**From:** Bloomer, David <David.Bloomer@lancashire.gov.uk>  
**Sent:** 09 November 2015 14:30  
**To:** Adam Birkett  
**Cc:** LHS Customer Service; planning  
**Subject:** app3/2015/0884 Sunningdale Chipping

Existing and Proposed Block
Plan & Location Plan

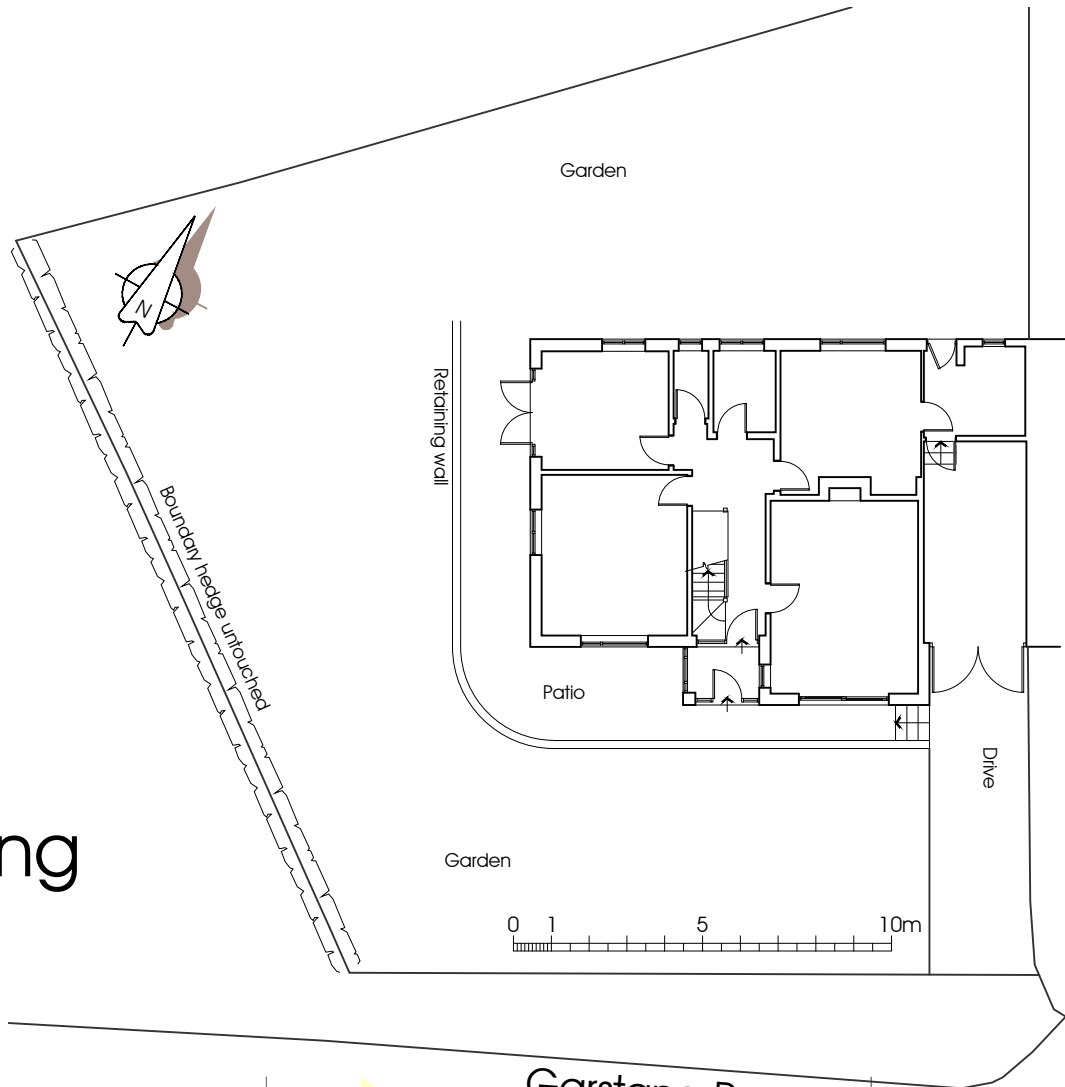
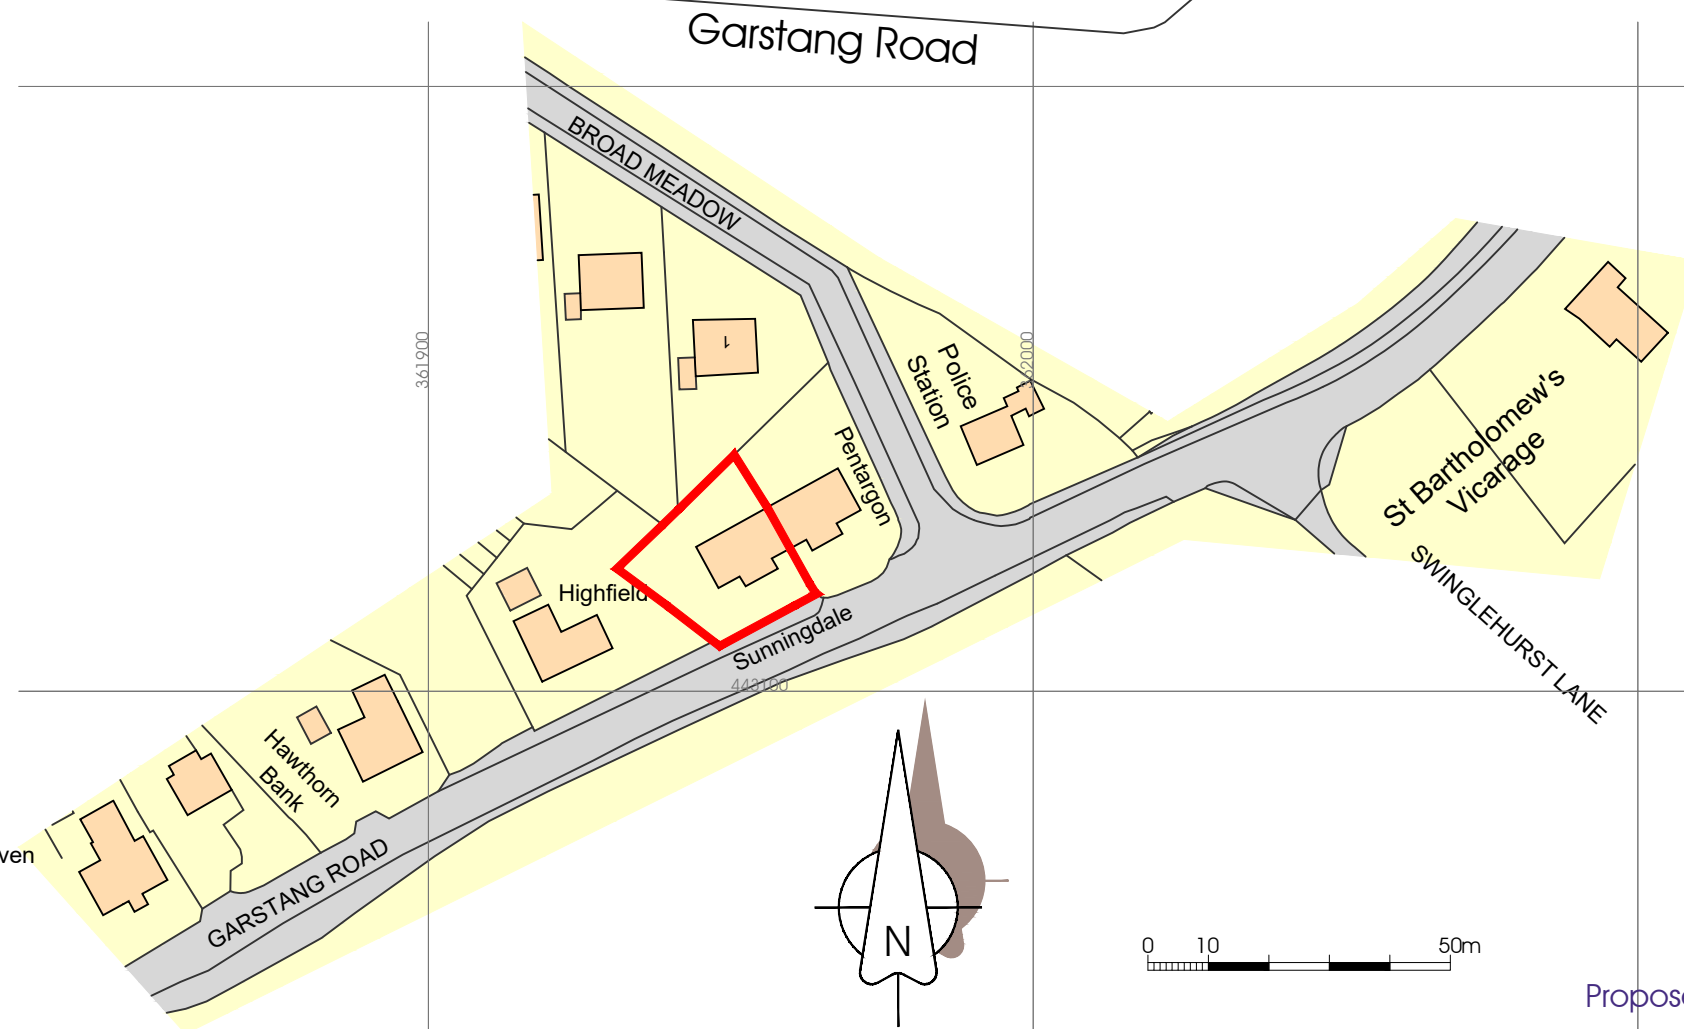
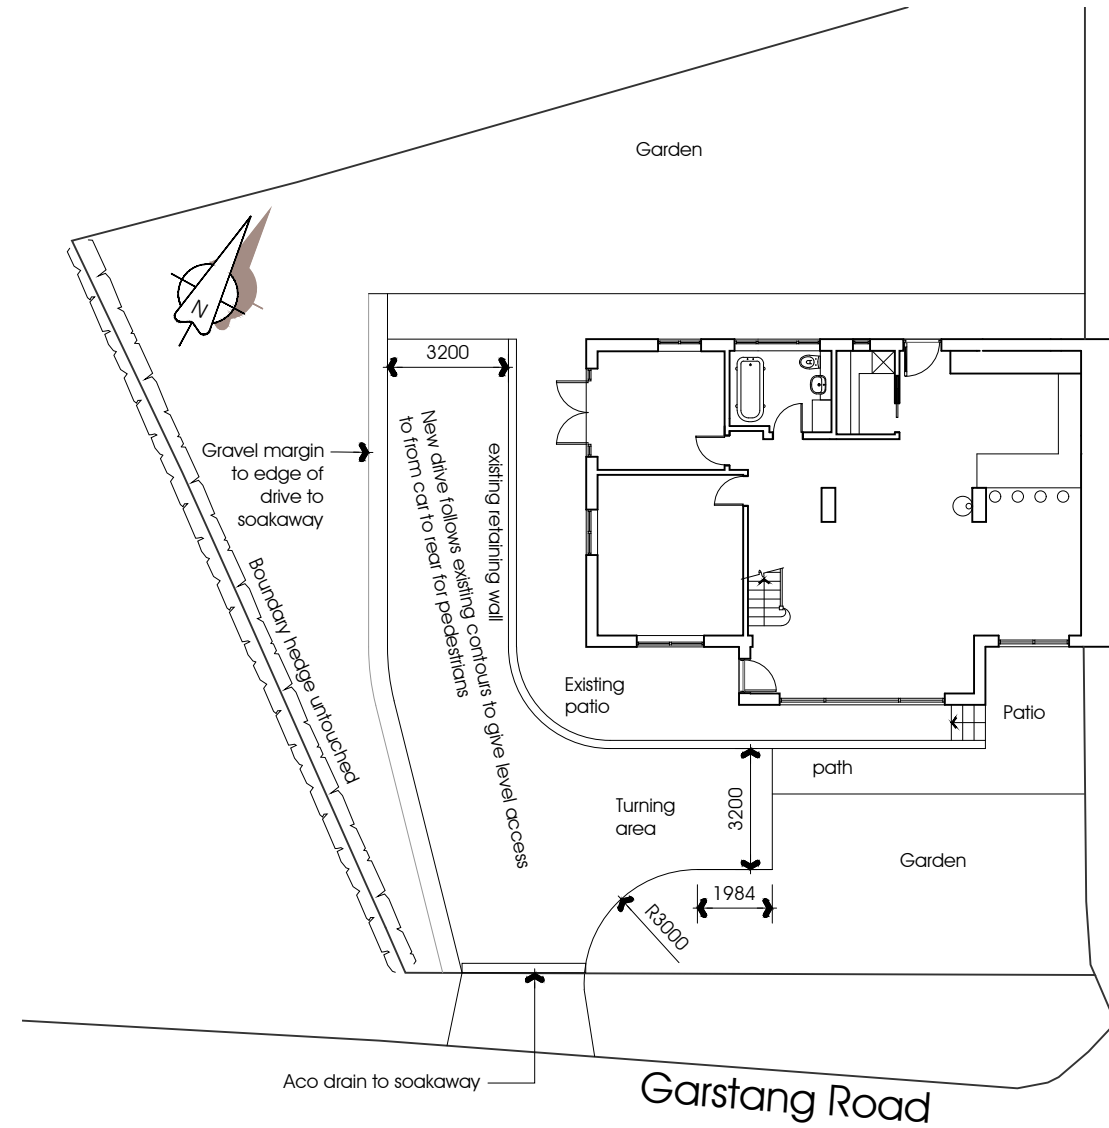
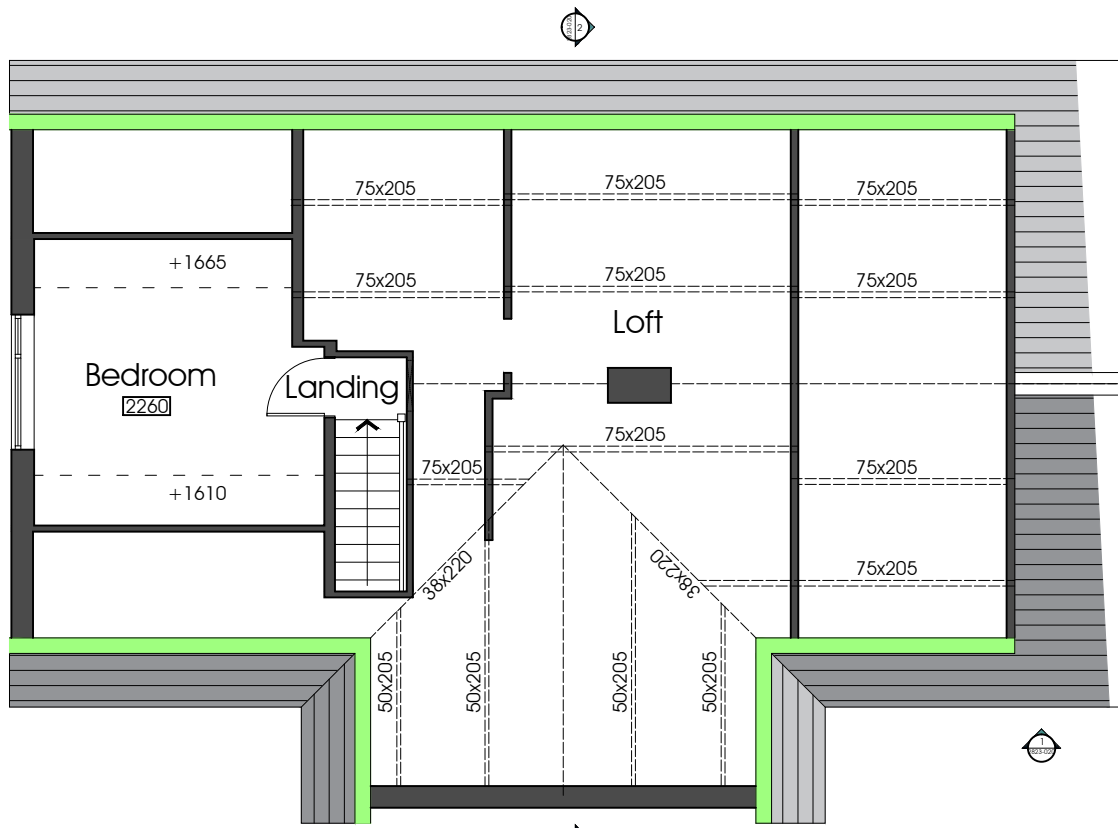
1. The existing access shall be physically and permanently closed and the existing verge/footway and kerbing of the vehicular crossing shall be reinstated in accordance with the Lancashire County Council Specification for Construction of Estate Roads concurrent with the formation of the new access. Reason: To limit the number of access points to, and to maintain the proper construction of the highway.
2. The vegetation to the west of the proposed access shall be removed for a minimum distance of 2.4m into the site measured from the carriageway boundary. Reason to provide acceptable visibility for vehicles emerging onto the highway from the new access to prevent.
